Drainage Report_V2.pdf Markup Summary

HISTORIC DRAINAGE MAP  
CROSSROADS MIXED USE  
JOB NO. 18-003  
DATE PREPARED: FEBRUARY 23, 2021  
DATE REVISED:

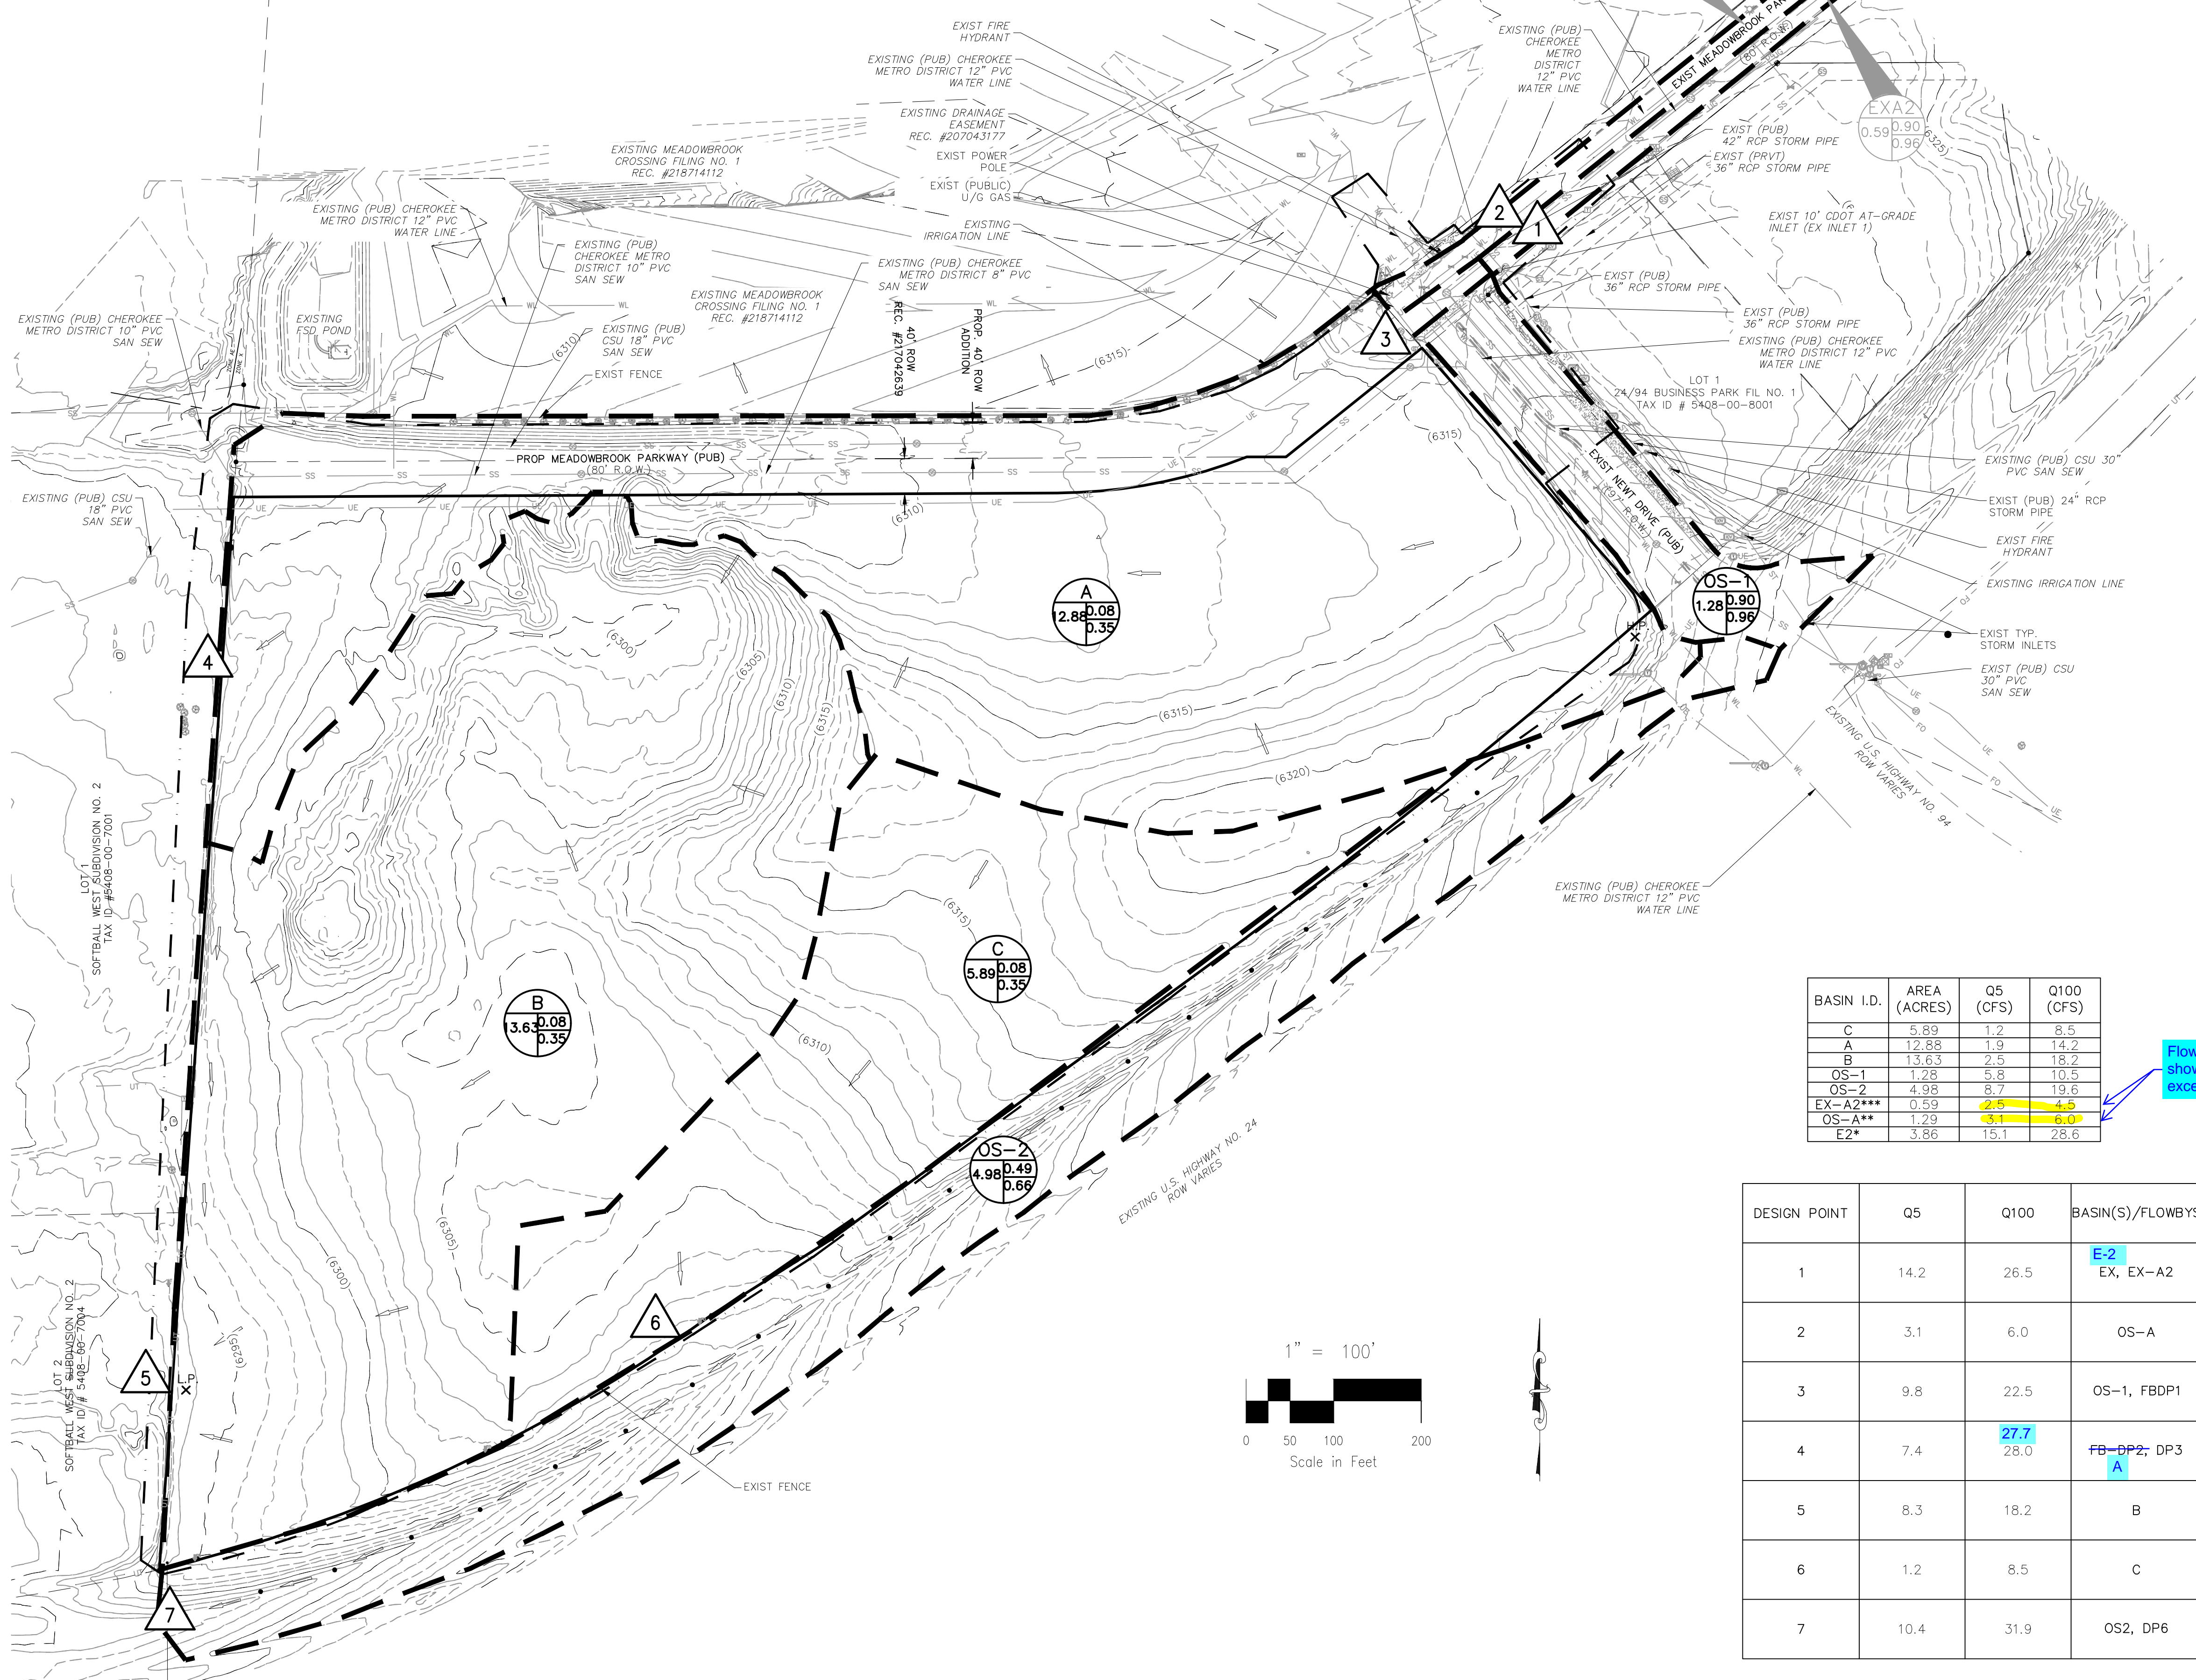
Does not match flows shown on FDR drainage plan for Lot 1 24/94 Business Park Filing 1

Flows do not match those shown on previous report excerpts
